NC Truss Design and Manufacturing

3/27/2024

Subject: DR Horton Lot 40 McKay

PROJECT:  
 Call - 181  
 Roof Framing Plan

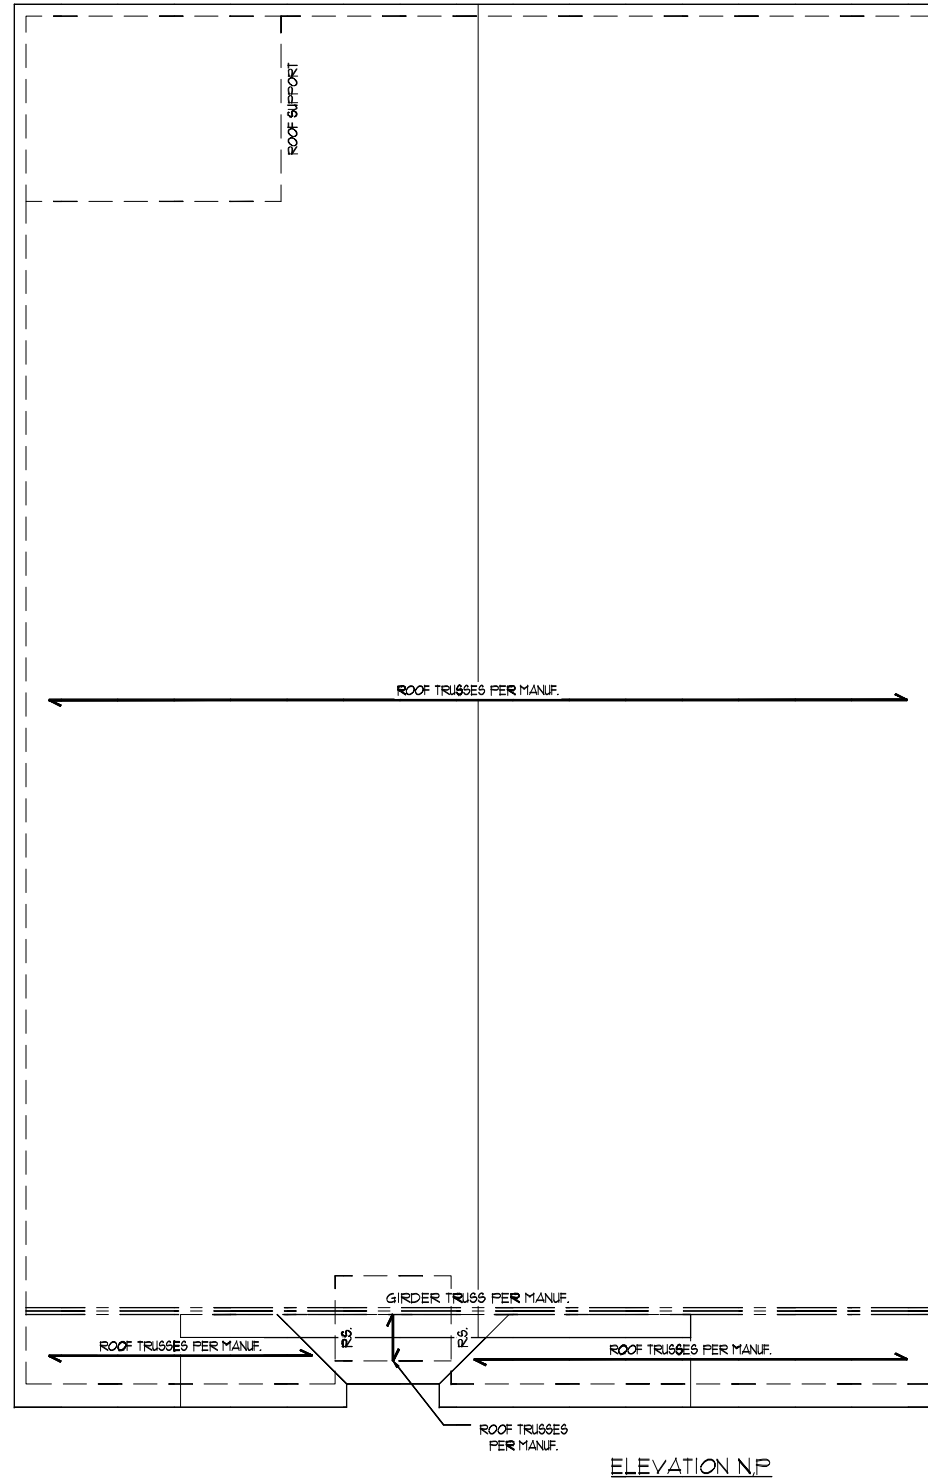
The installation team switched the positions of two trusses, an A09 and an A12. Fortunately, the design of these two trusses uses exactly the same lumber and plates and the trusses are identical in their manufacture. The only theoretical difference is the interior bearing but the actual sealed designs are the same and because of this they are interchangeable in the installation.

Having reviewed all of the drawings and the installation, we are satisfied that this assembly will perform within code and within all of our original design parameters. Please feel free to contact me on this or any other truss project.
